TAG PEER REVIEW- WOODFOLD VILLA, SHORROCK GREEN, MELLOR, 30 September 2022

The TAG Peer Review Group was asked by Francis Shaw of Shaw & Jagger Architects, the applicant's agent, to undertake a follow up review regarding the scheme subsequent to the Applicants' pre-application submission with the local authority and our review of 15th June 2022 (which should be referred to in the context of the below).

The application is to be made as an NPPF clause 80e application.

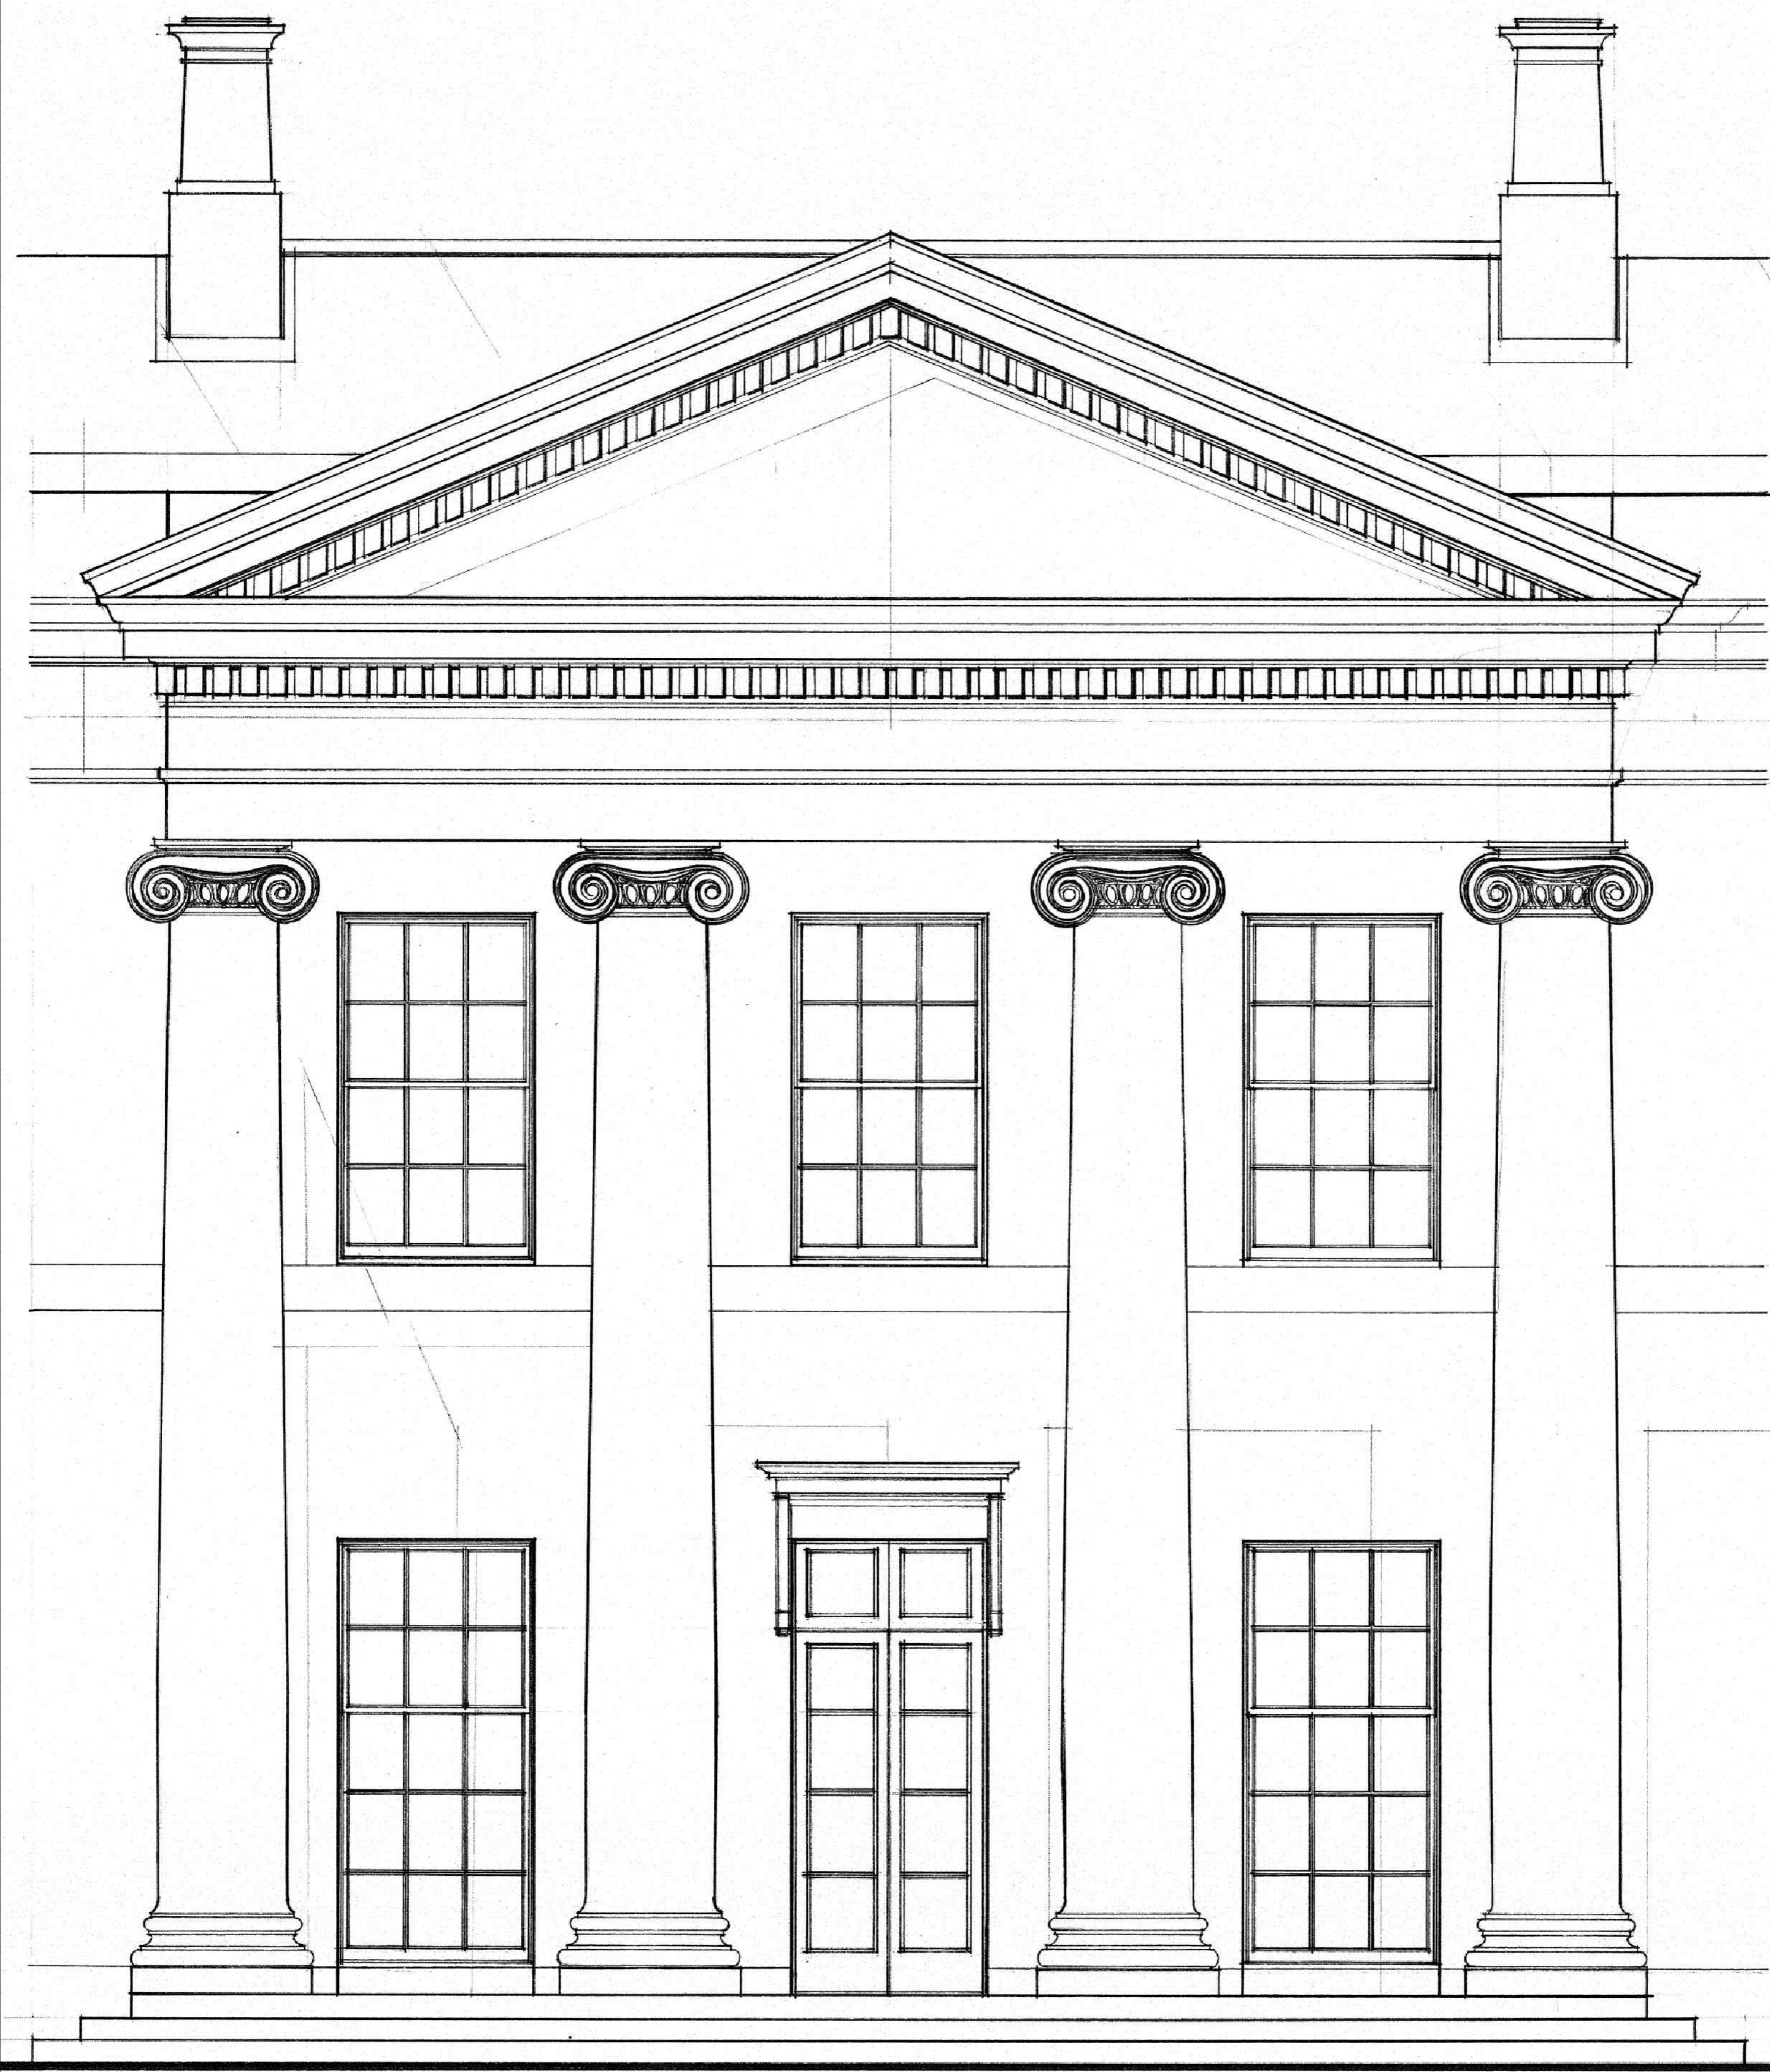
Further information was submitted regarding specific building details such as those for the Ionic columns and the front pediment. The panel suggest the detail of the classical composition be refined and dealt with in a holistic fashion and with regard to rest of the design and classical canon. The portico is the defining architectural element of the proposed building and it must be clearly and correctly interpreted.

Claverton Manor and Woolley Park are cited as examples where Wyattville used pilasters or full columns to terminate the colonnades.

Woodfold Villa

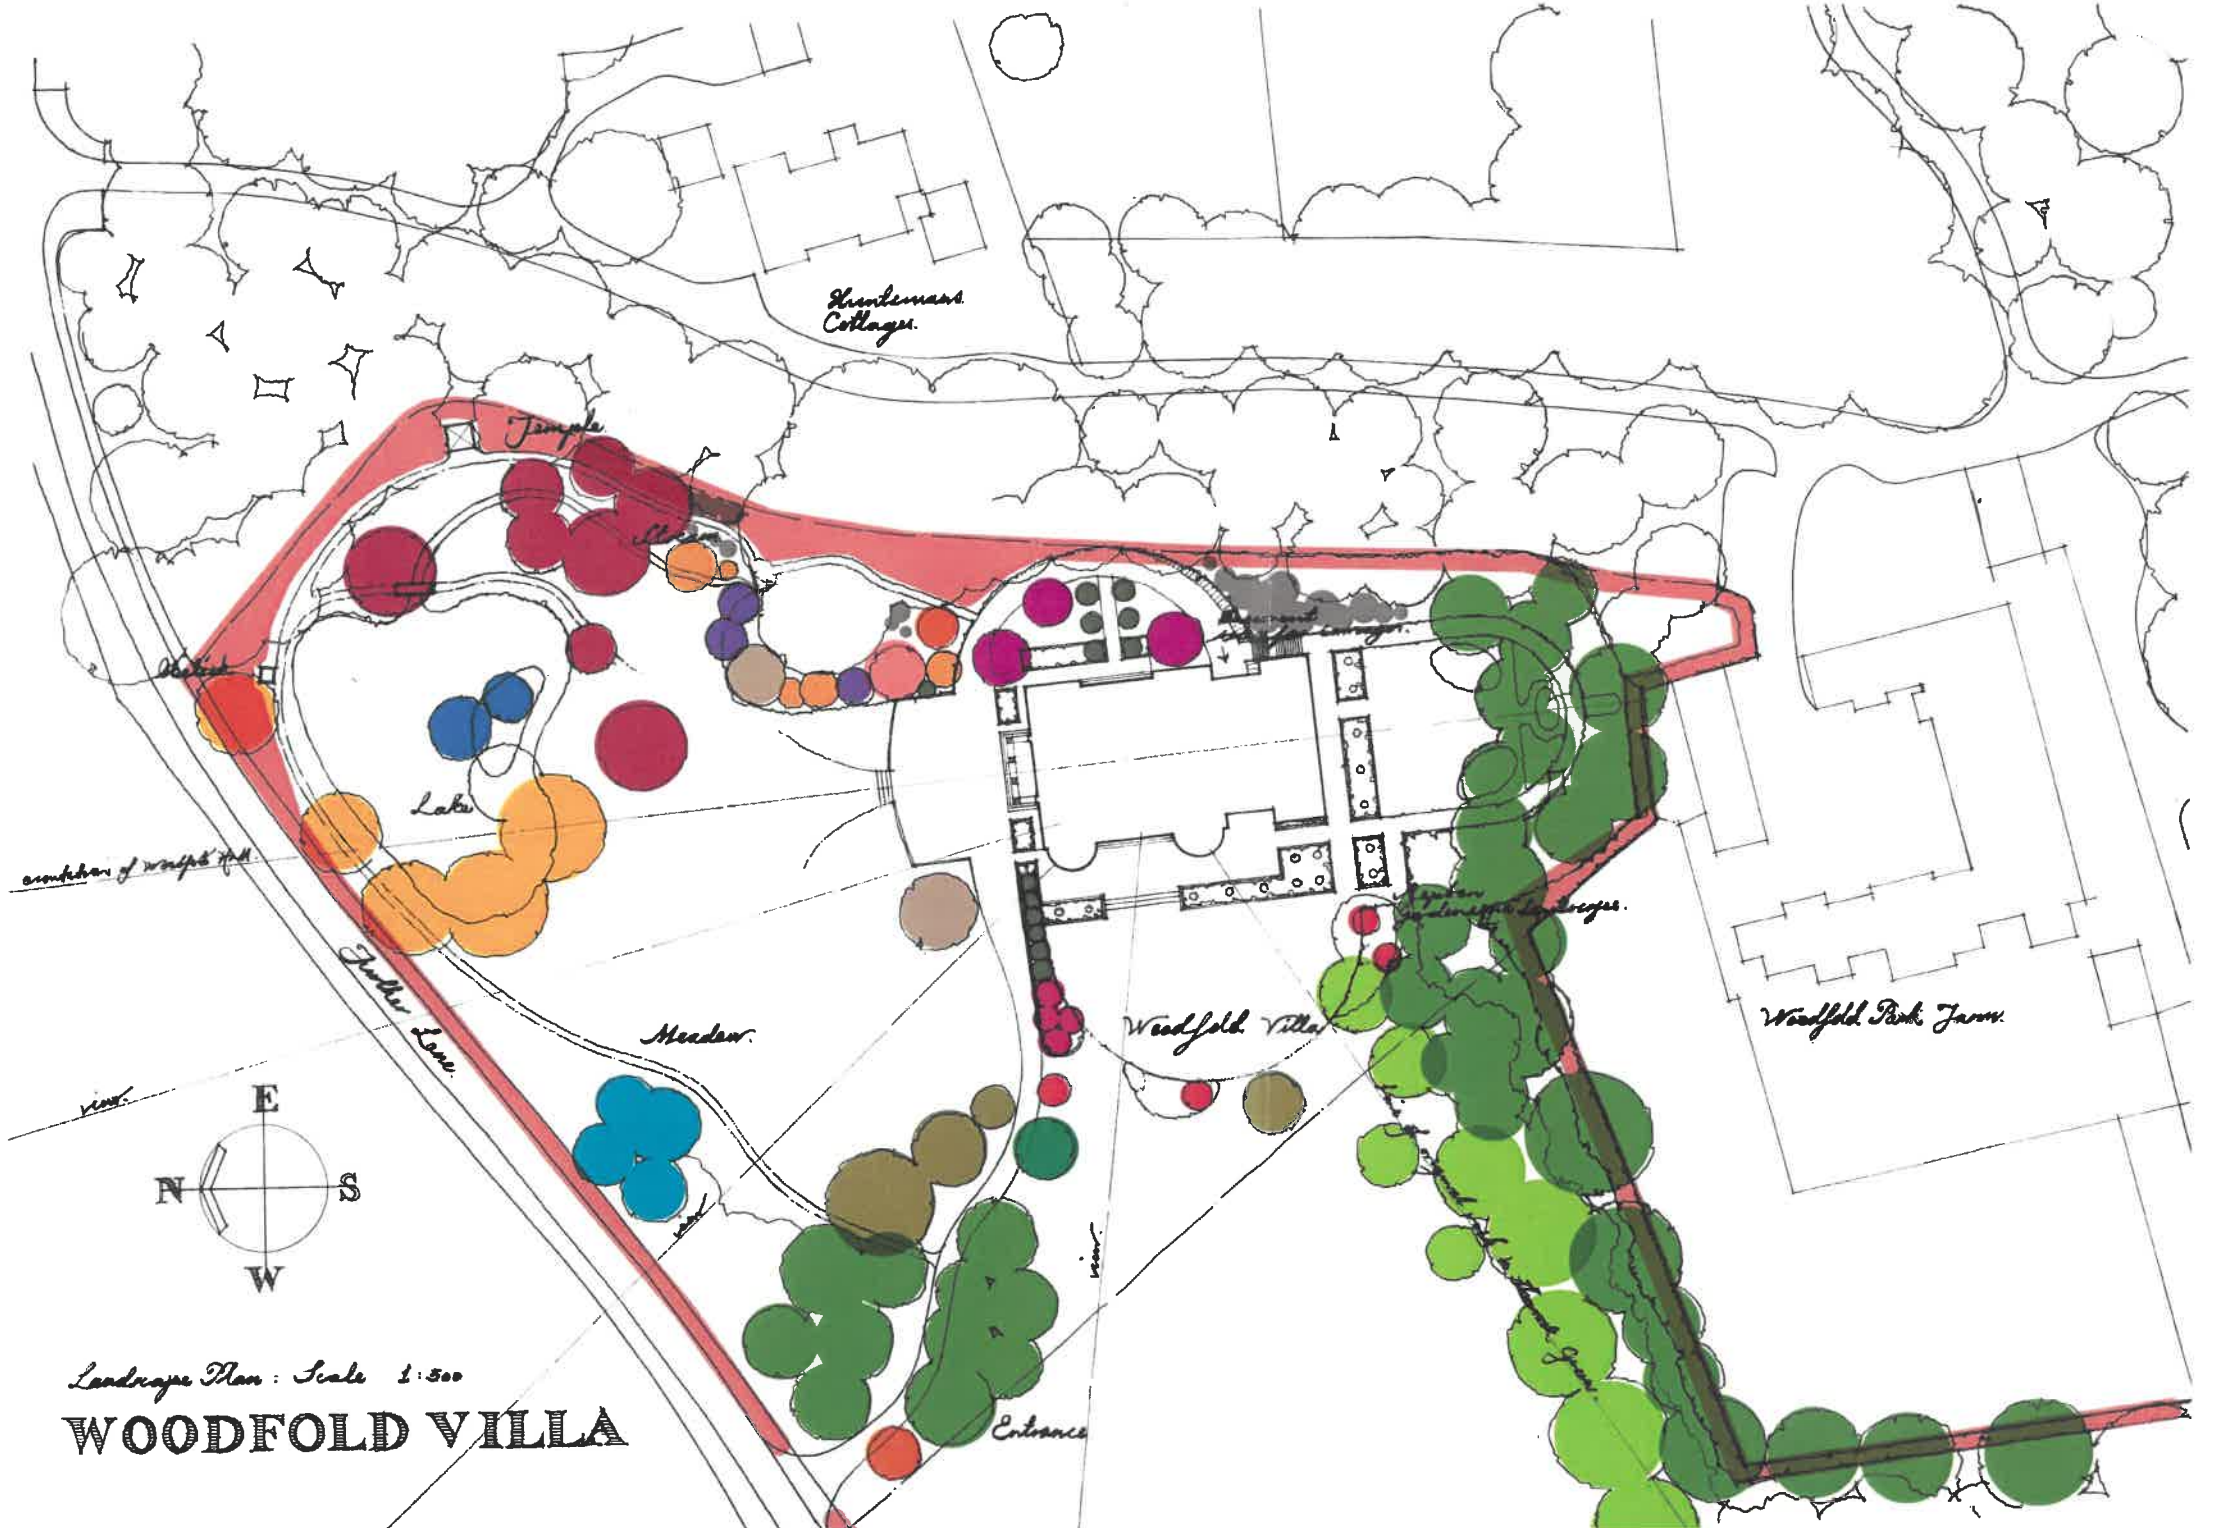
- Hedge along Further Lane now shown on the landscape plan and 3D view;
- The proposed entrance pillars on the landscape plan and in the 3D view;
- Lake moved a little further away from the boundary with Further lane, to allow room for the boundary hedgerow;
- Planting now shown more accurately on the 3D views, including detail of the terraces/ planting beds around the house; and,
- Show the differentiation between close mown lawn grass and meadow on the landscape plan (where it might occur). Show marginal planting around the lake on the landscape plan.
